Project Name: ROMERO ADDITION

DATE: August 4, 2008
TO: Jack Cloud, DRB Chair
FROM: Catalina Lehner, Senior Planner *CLL*
RE: Project #1004731, Sawmill Law Office 2

On May 17, 2007, the EPC voted to approve an "as built" Site Development Plan for Building Permit for Lots 19, 20-24, Romero Addition, zoned "SU-2 for SU-1 for Residential and/or Law Office, Court Reporter, Accountant, Architect, Engineer, Doctor Office." Staff met with the applicant, Architect Berent Groth, on January 8 and April 24, 2008, to check for compliance with the Conditions of Approval.

**SITE PLAN - (EXISTING AND PROPOSED IMPROVEMENTS)**

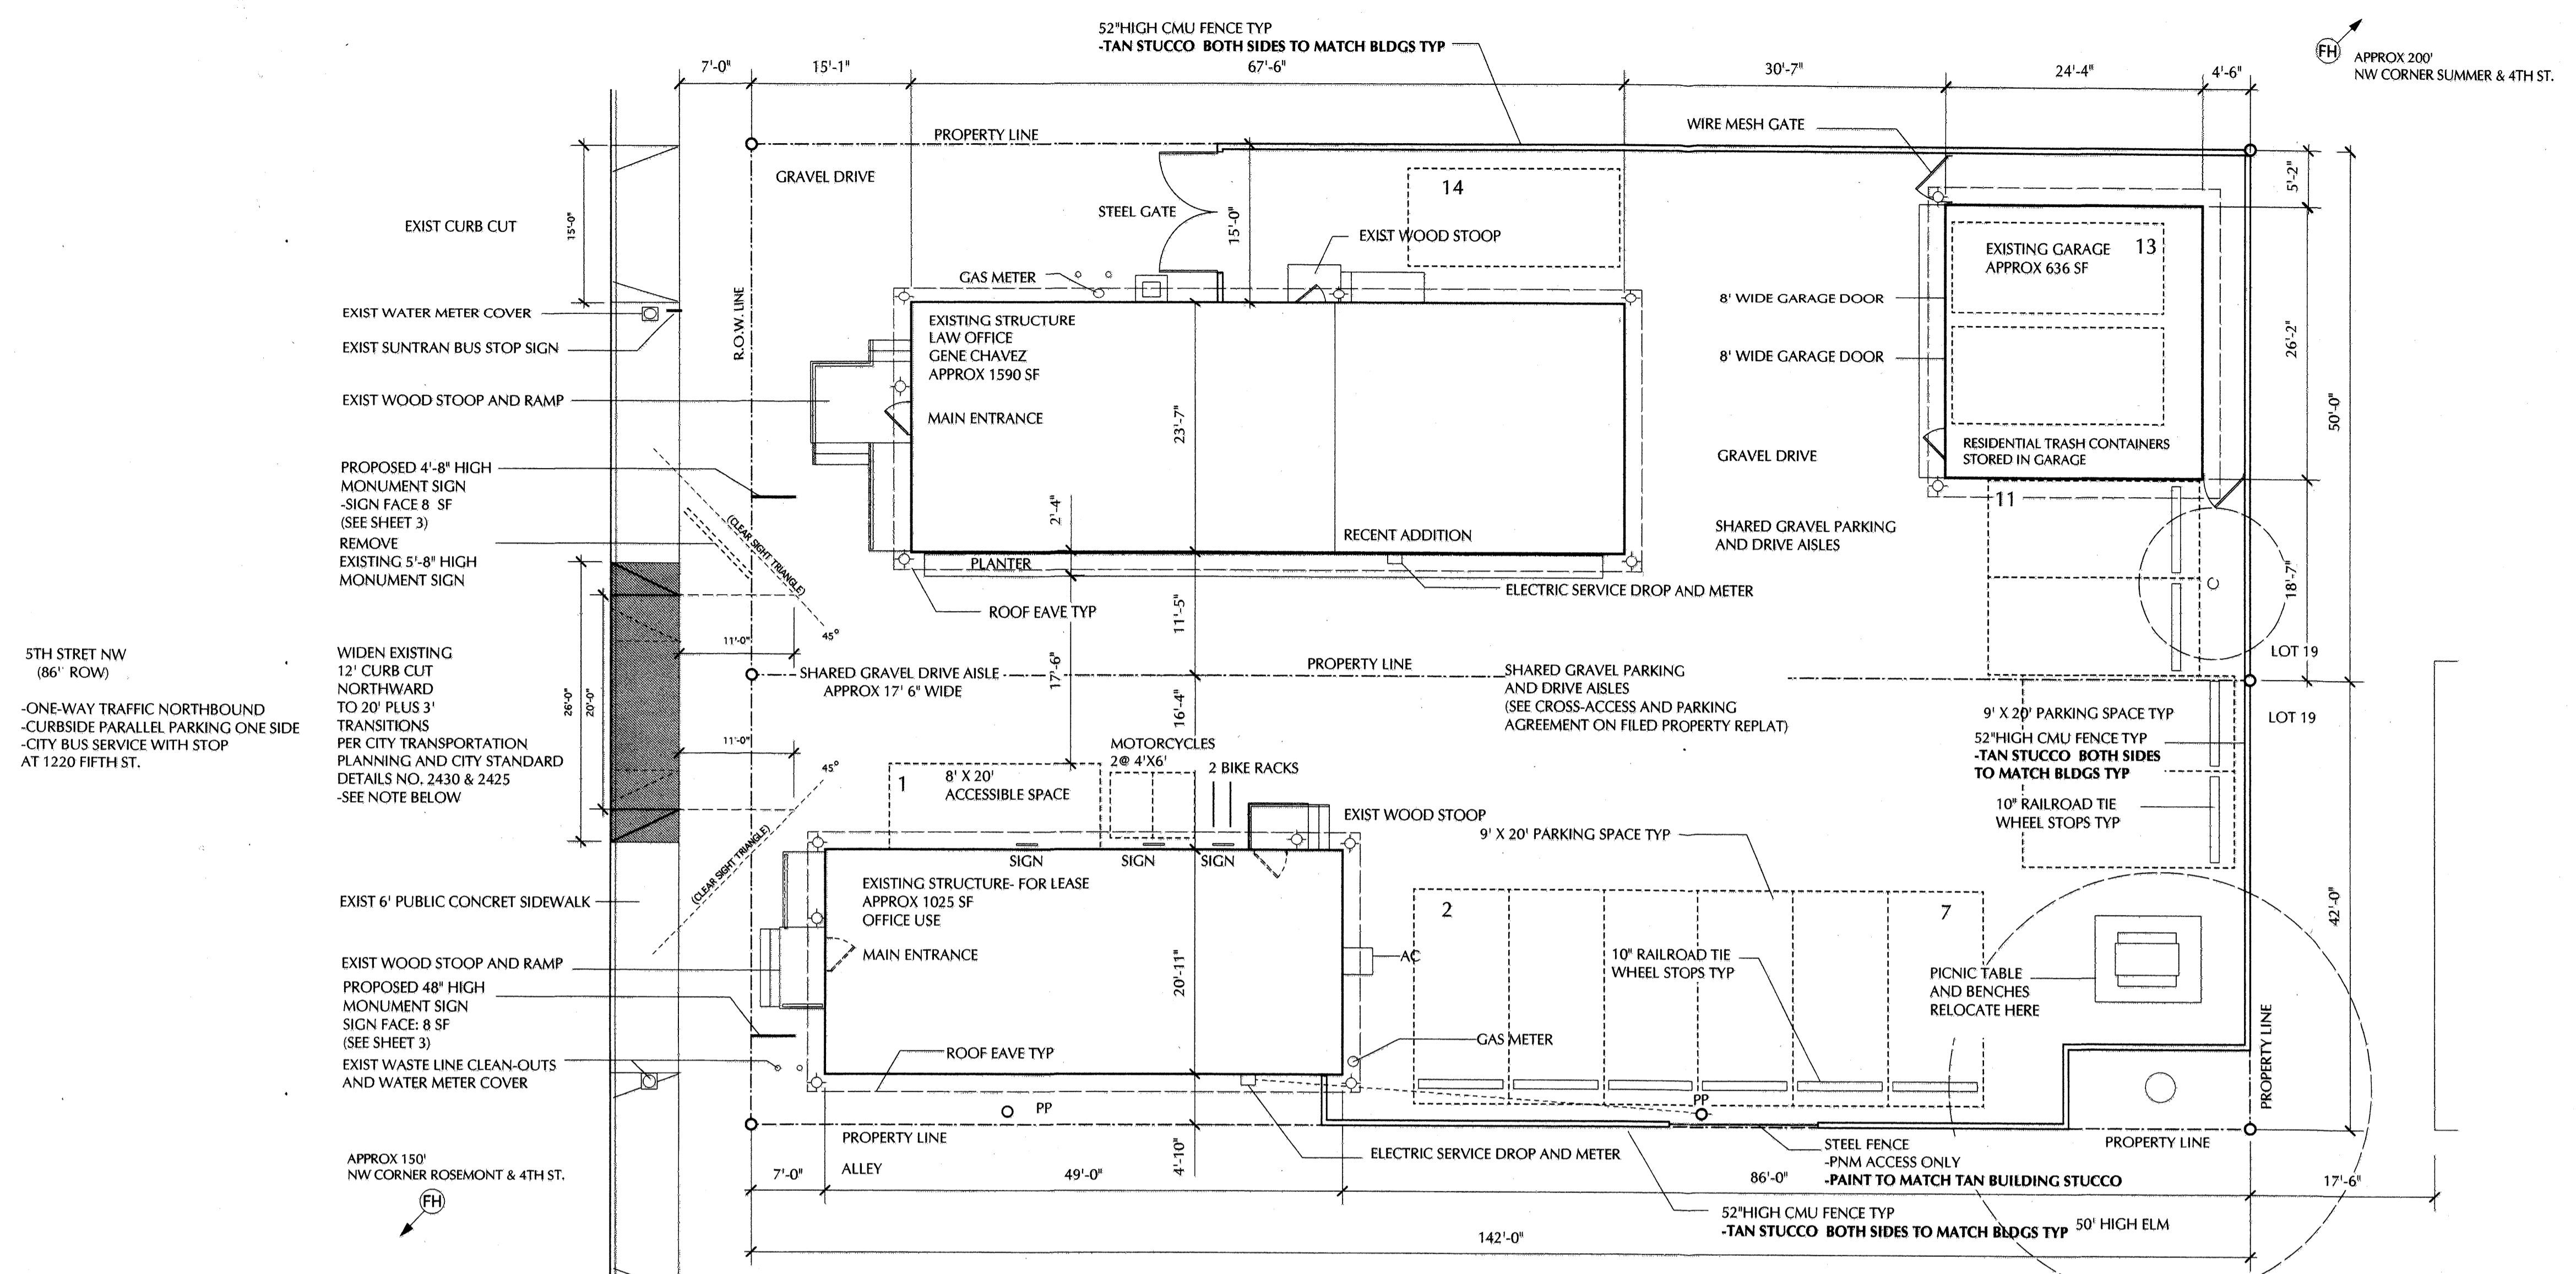
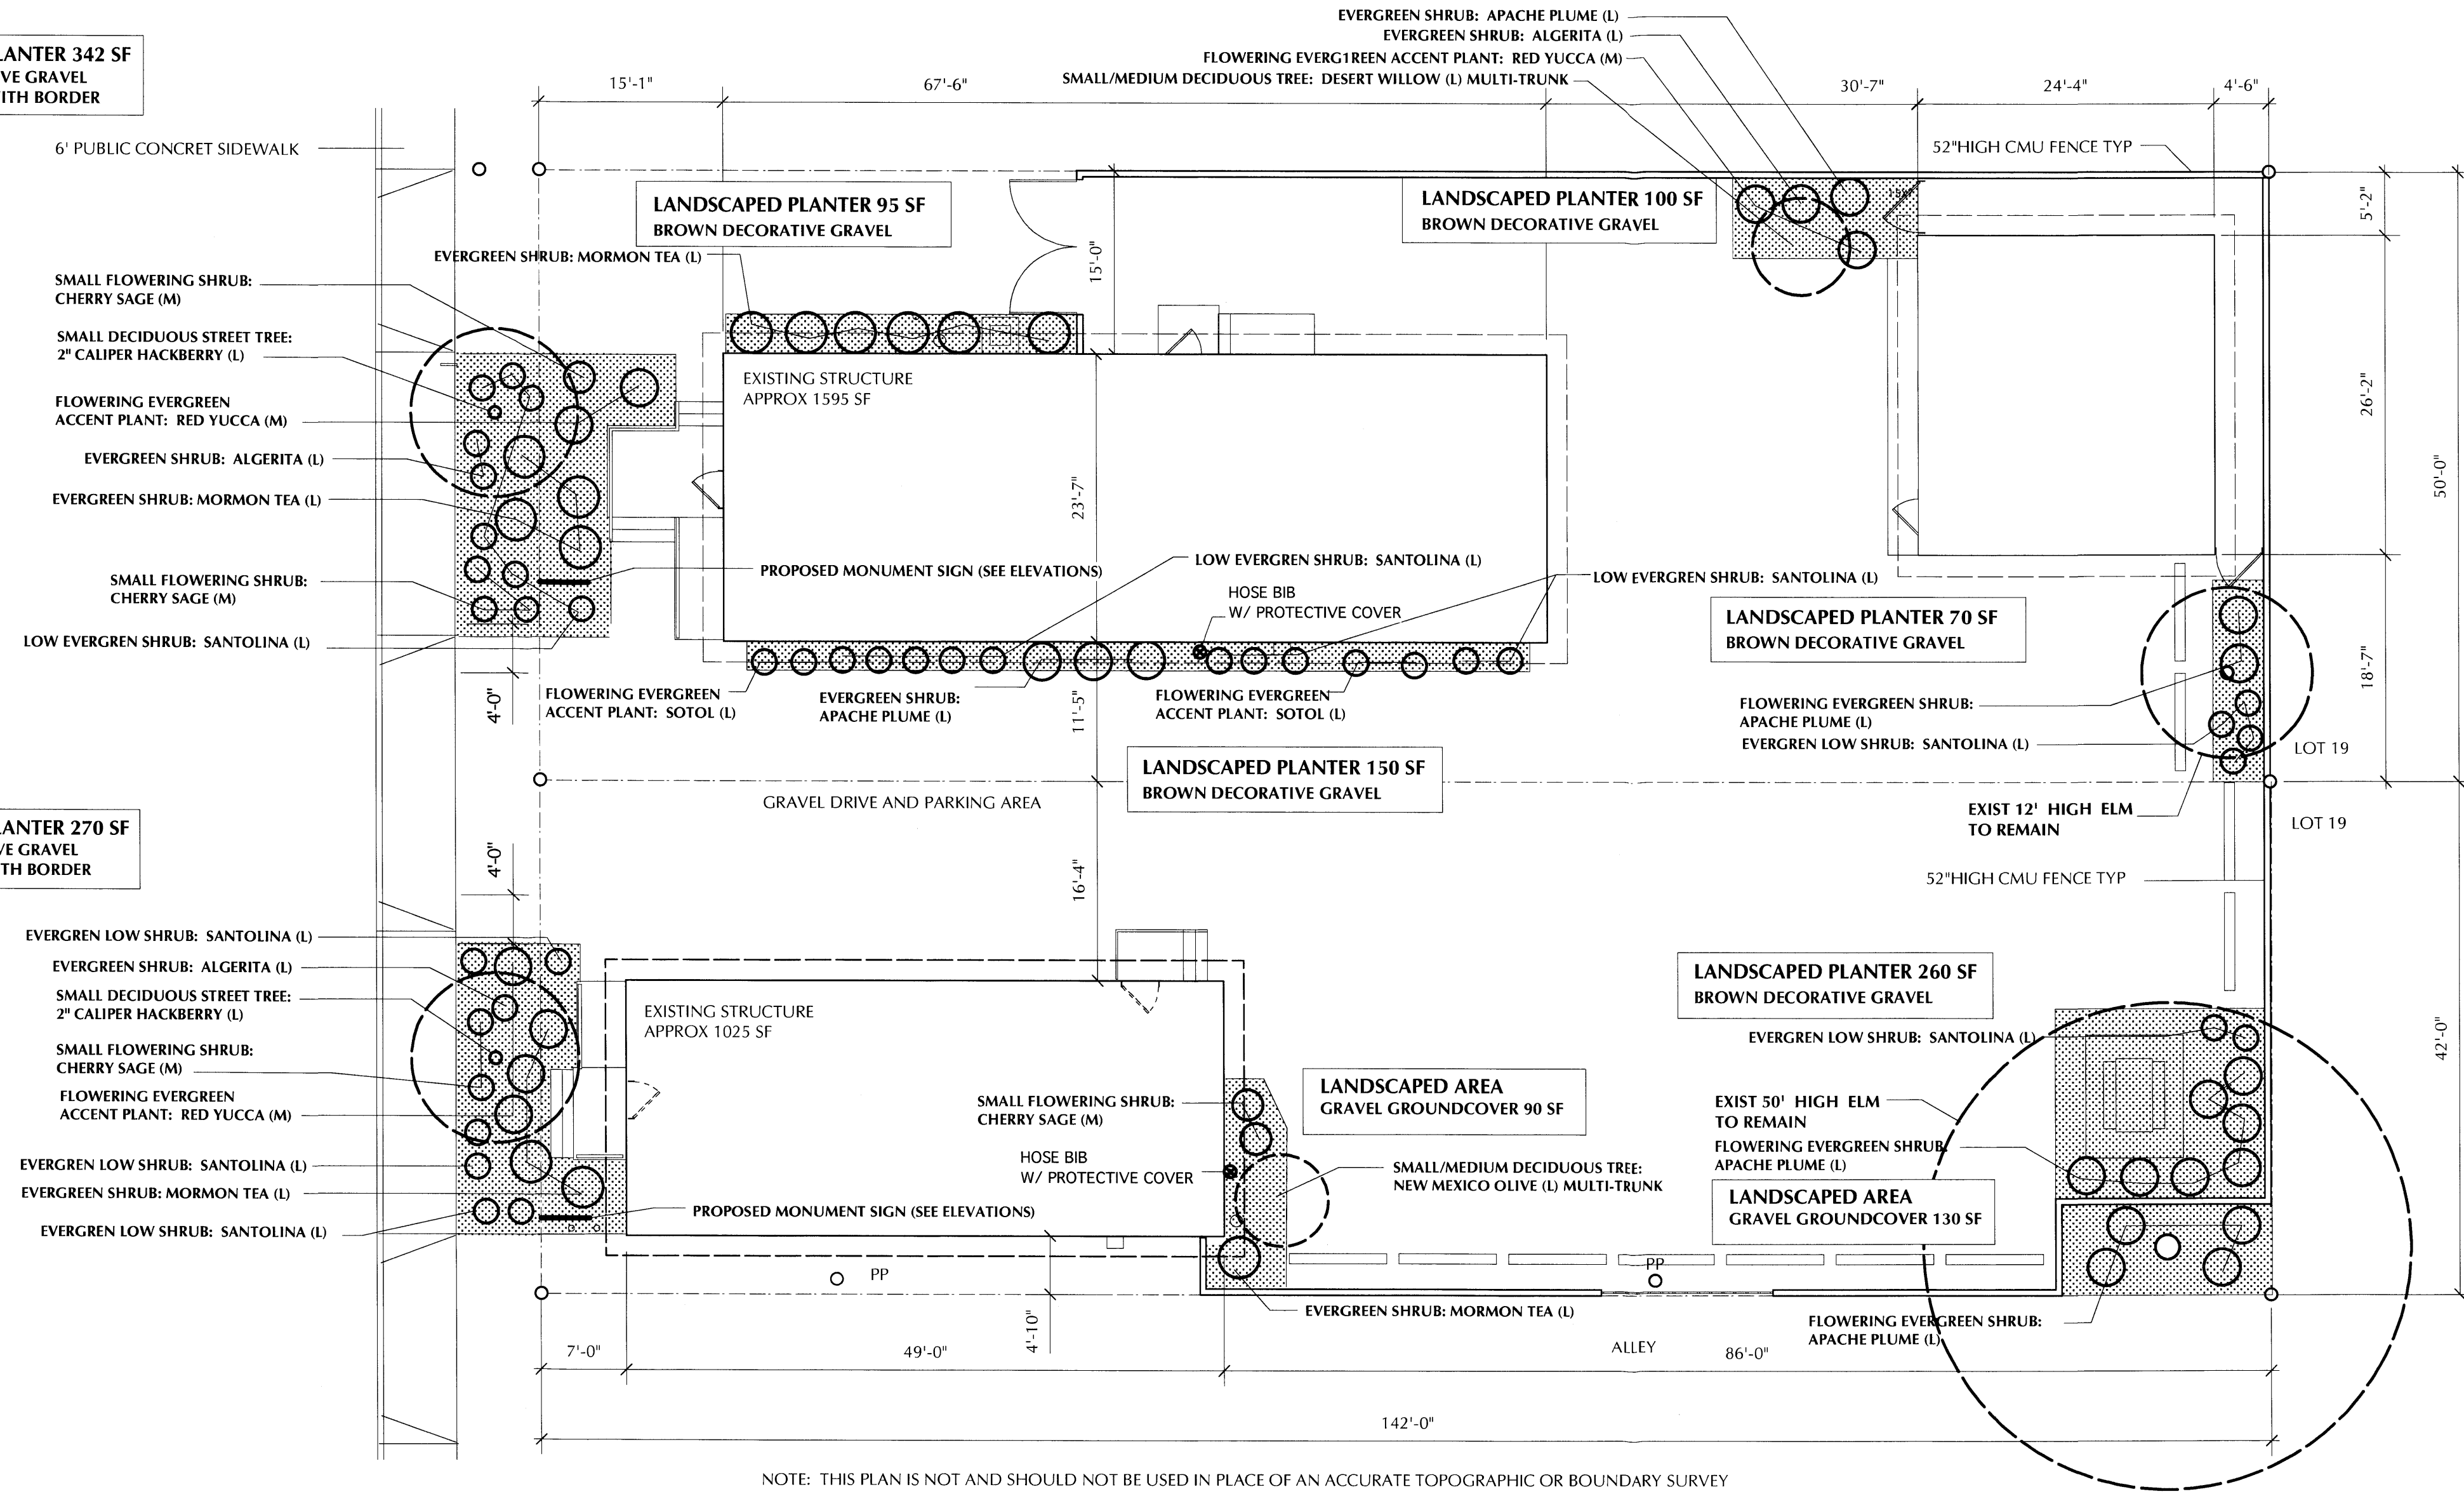
Condition 4B: The stucco wall of the CMU wall, which must match the building, needs to be specified on the site development plan as either tan or light brown.

Condition 8: A note shall be added to the site plan to indicate that "The residential carts for refuse collection shall not be visible or located in the garage".

PROPOSED MONUMENT SIGNS (See Site Plan)  
scale 1/2" = 1' - 0"

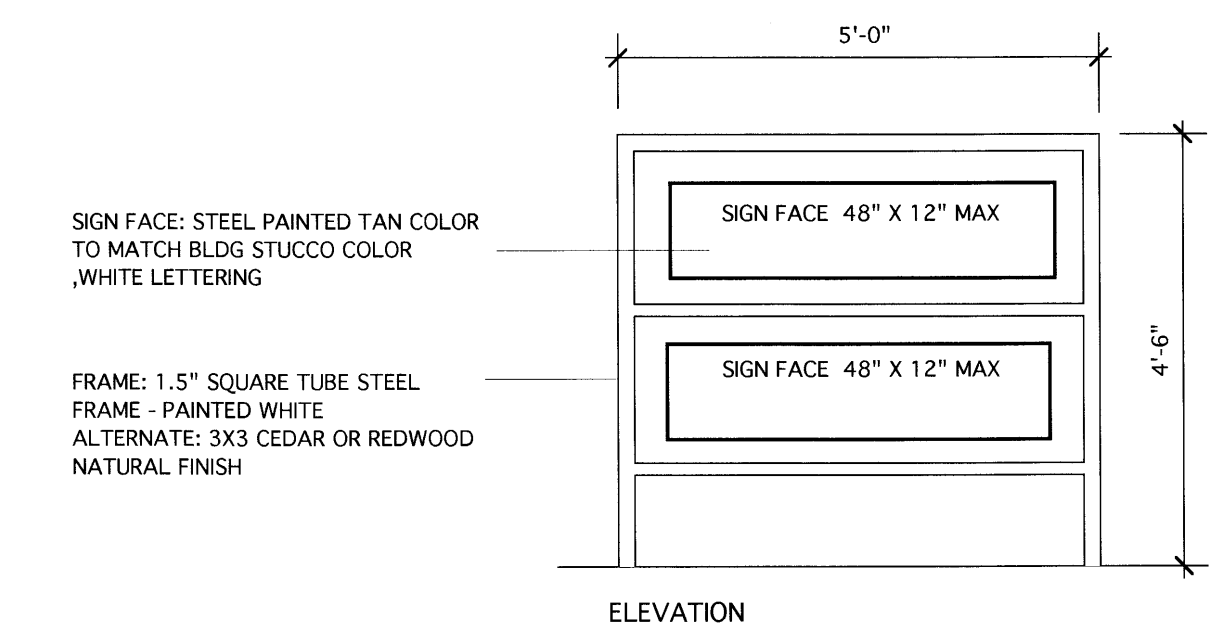
Signage: Note the following change from the sign detail approved by the EPC: the sign frame is specified as Black. The sign detail approved by the EPC specified White.

<i>Current Sign</i>	<i>Revised Sign (pursuant to site plan)</i>
5 ft. high	4.5 ft. tall
5.5 ft. wide	5 ft. wide
3 sign faces, 3.3' x 0.83'	2 sign faces, 4 ft. x 1 ft.
Approx. 8.22 sq. ft. of face area	Approx. 8 sq. ft. of sign face area

Summary: The revised sign will be ½ foot shorter, ½ foot narrower and have 0.22 less feet of sign face area.
